From: Tom <[REDACTED]>
Sent: 04 Mar 2021 14:37
To: Amber Willard
Subject: Re: be/149/20/pl

Unfortunately, your application BE/149/20/PL at 339 Chichester Road is going to be refused due to insufficient information. I believe you were intending to speak to WSCC however I haven't heard anything further and haven't had a response from WSCC to confirm anything otherwise.

SITE PLAN

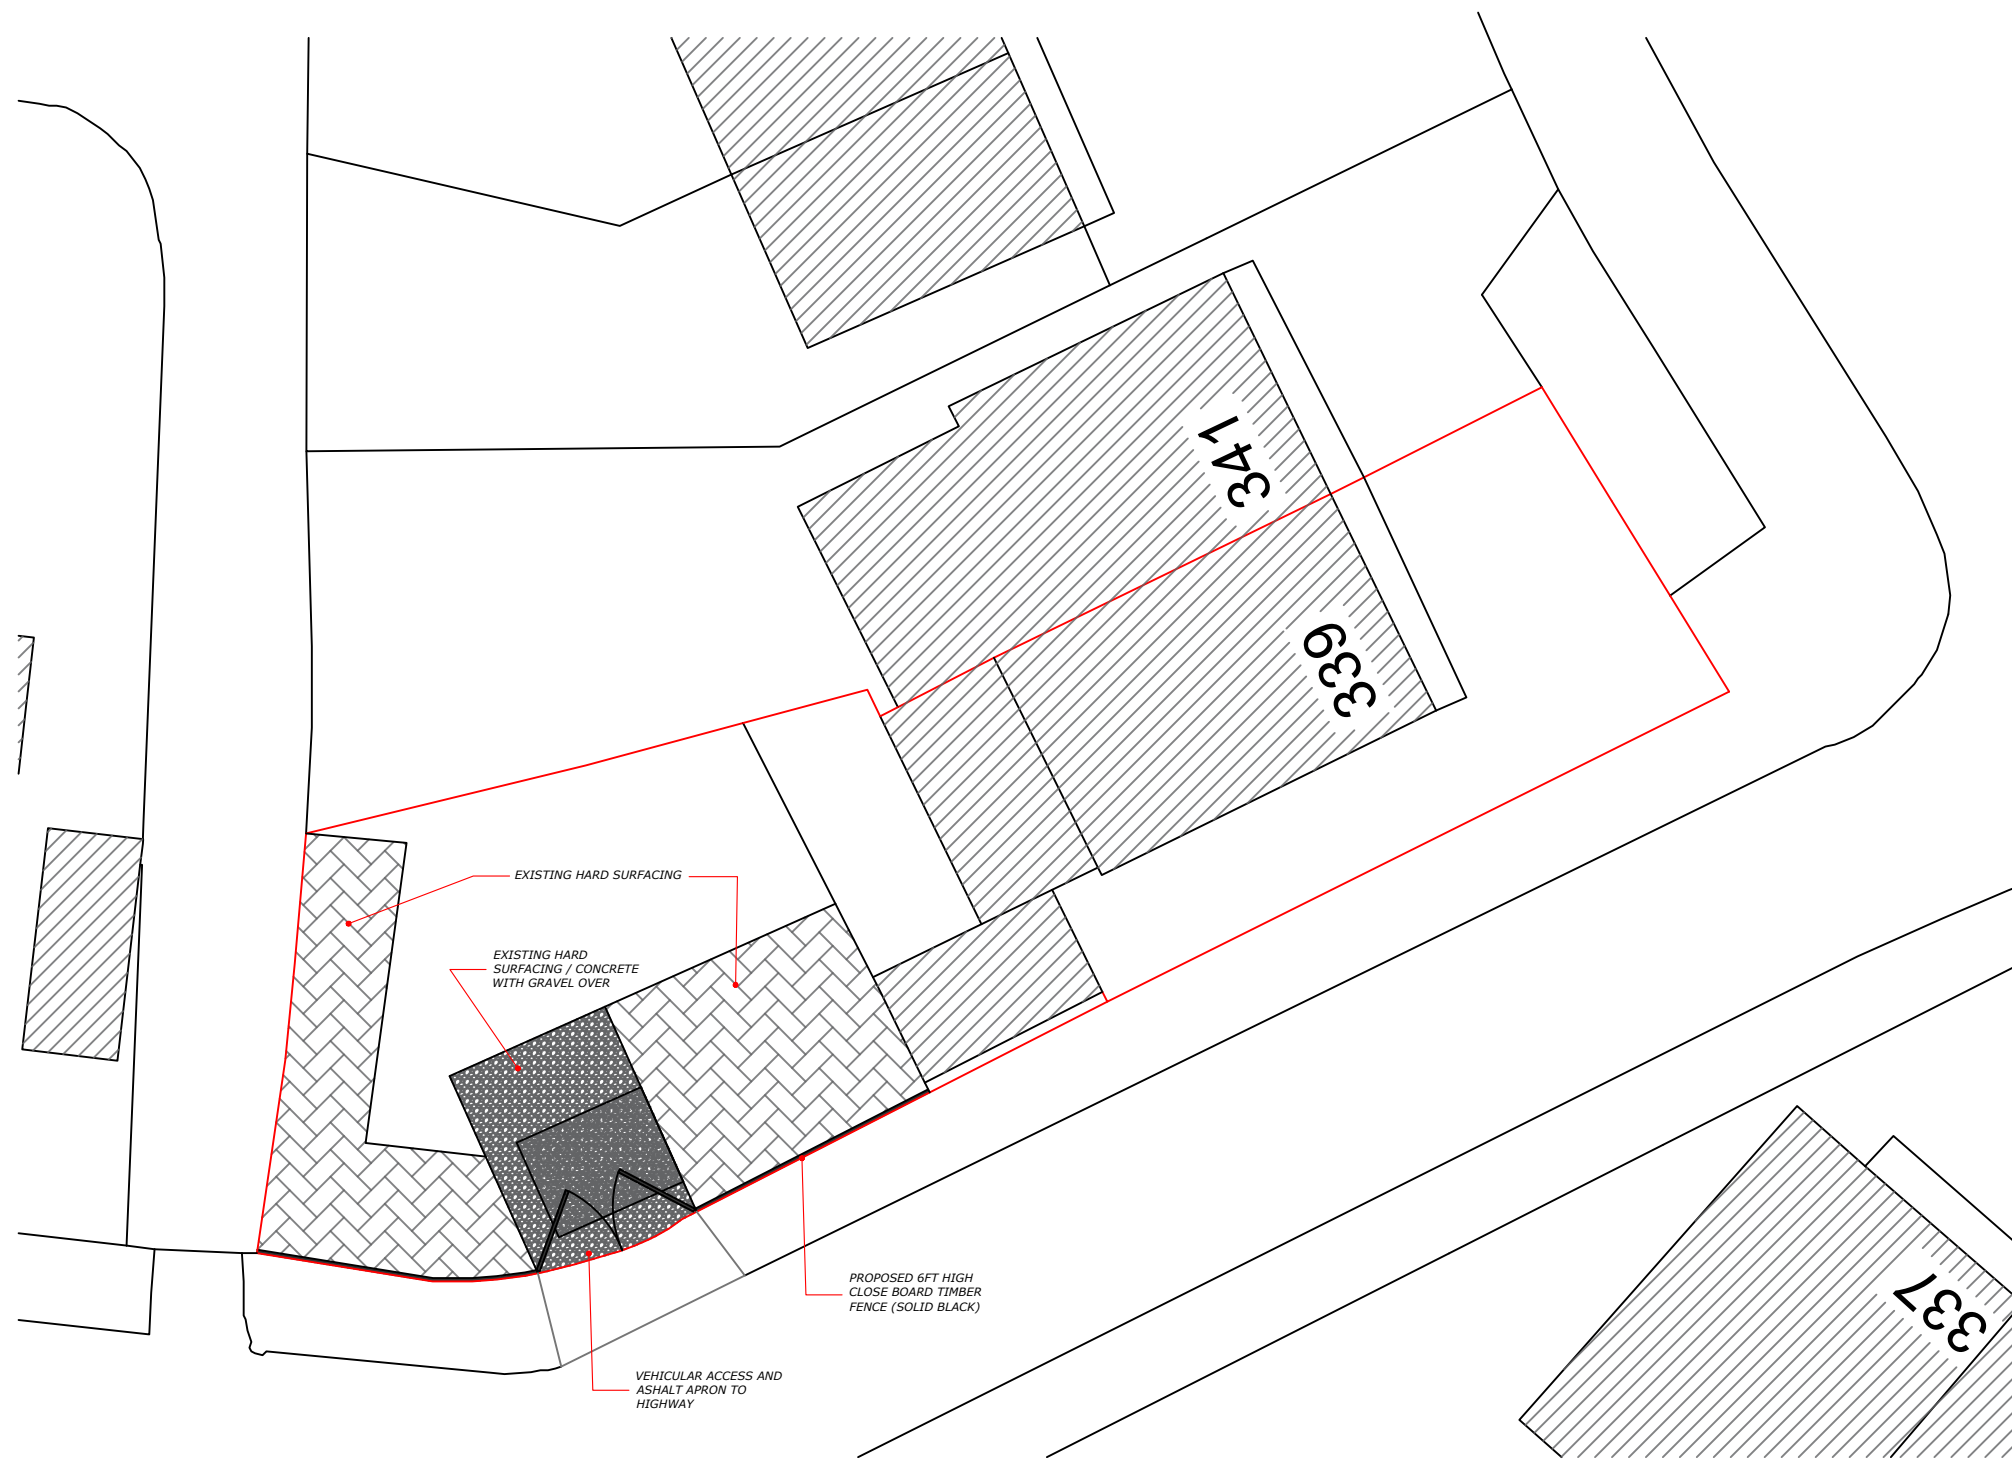
I have spoken to Darren Pring in highways and it seems that the slightly adjusted entrance would be the simplest solution.

You could alternatively withdraw and resubmit when you are able to provide the sufficient information which may include a 7 day speed survey to overcome the splays that may not be achievable on site.
